Subject: VA-25-00001 Roe - Notice of Application

TO: All Staff
FROM: Public Works Plan Review Team
DATE: April 16, 2025
SUBJECT: VA-25-00001 Roe

SUBJECT: WDFW COMMENTS ON VA-25-00001 Roe

Critical Areas Map

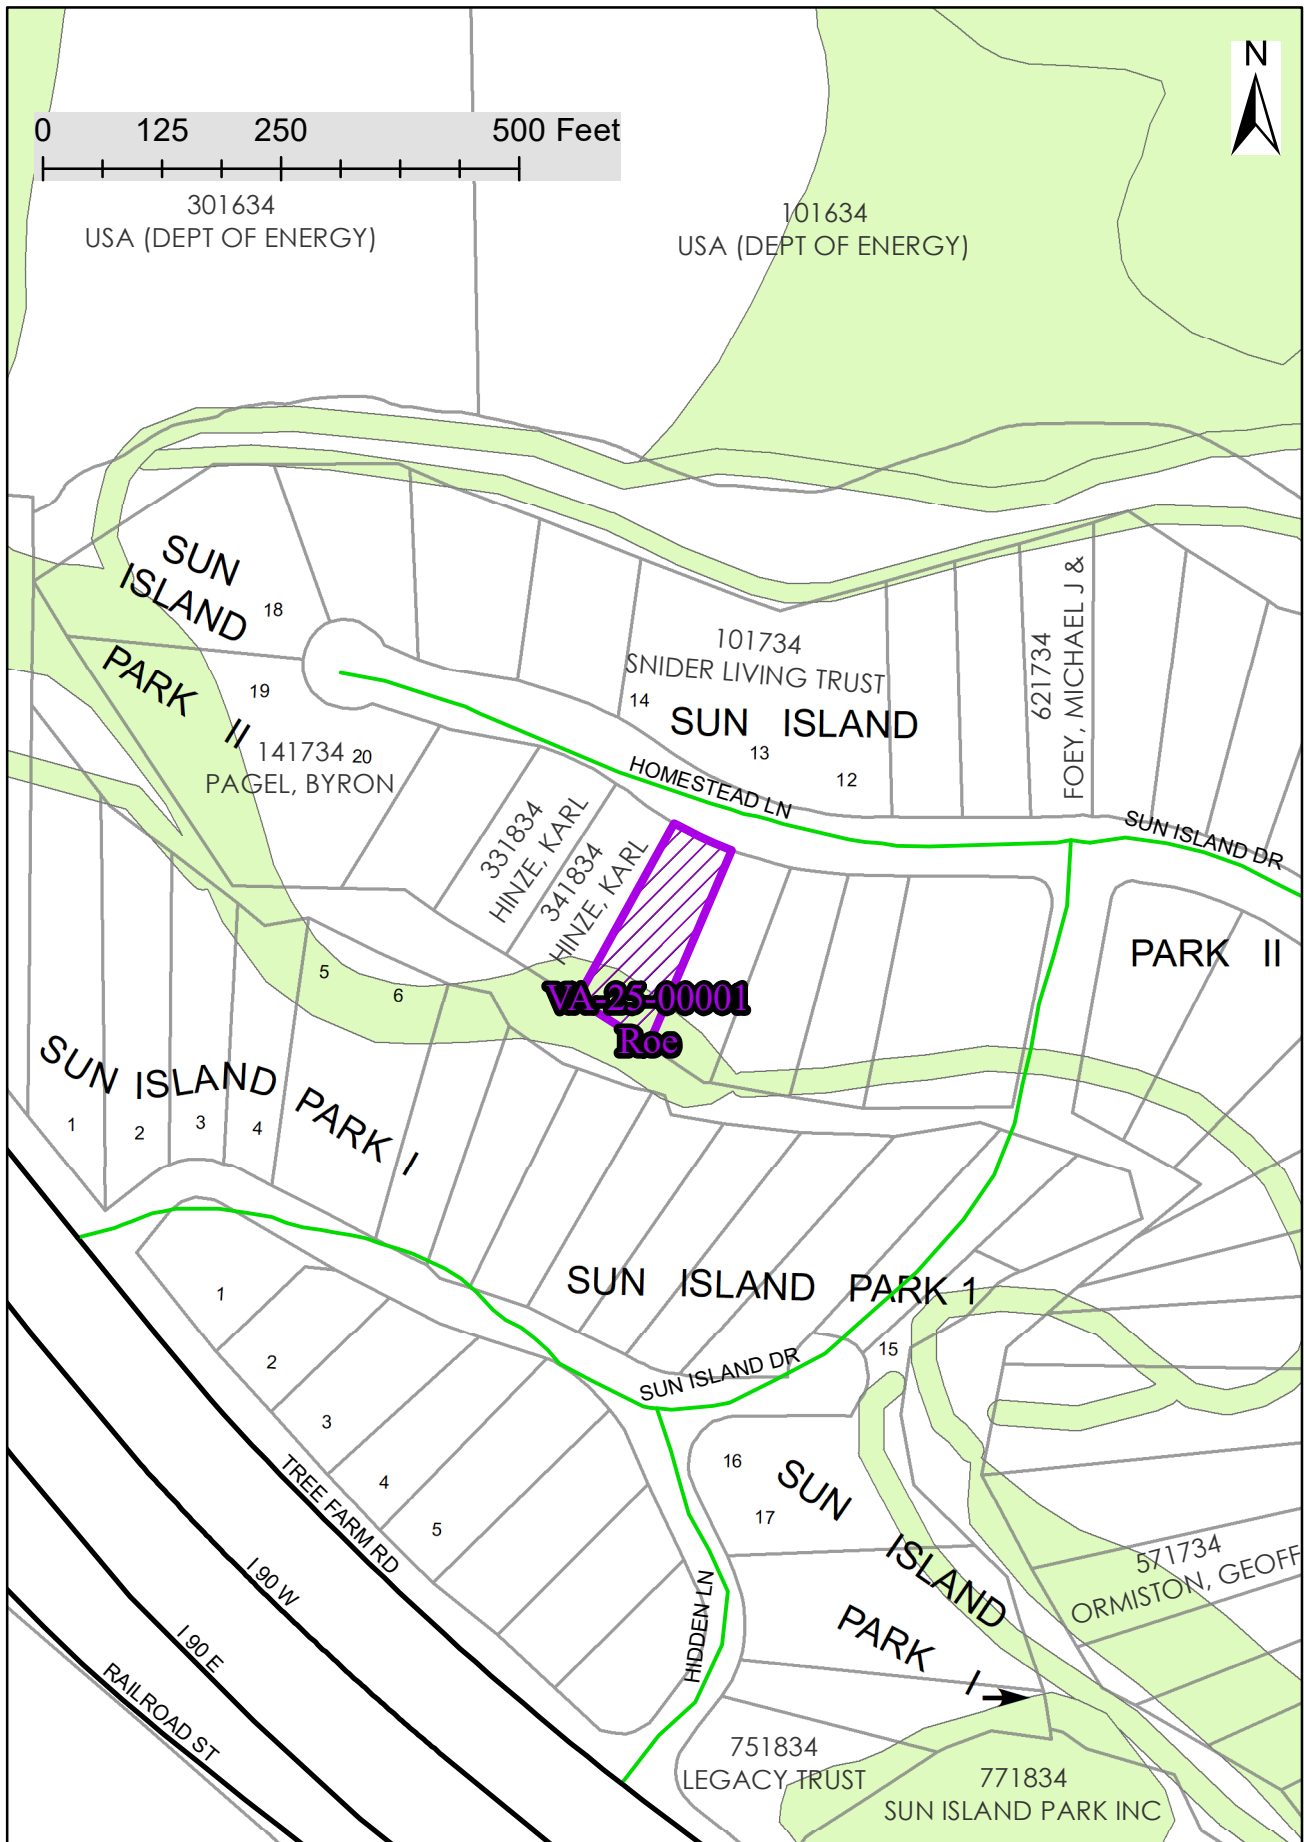
SURVEY	No Comment
TRANSPORTATION CONCURRENCY	No Comment
FLOOD	Per KCC 14.08.300 new construction is prohibited within the floodway unless a FEMA approved LOMA or a no-rise certification completed by a registered professional engineer is provided. If an approved LOMA or compliant no-rise cert cannot be provided, the structure must be removed from the property. (SC)
WATER MITIGATION/ METERING	No comments. (SC)
AIRPORT	No comments. (JS)

The property is wholly within the 100-year regulatory floodway and is mapped Shoreline Residential under Kittitas County's Shoreline Master Program. We understand this is an existing structure; however, the impacts to the floodway and Yakima River Riparian Management Zone (RMZ) should still be evaluated as they would with a new structure.
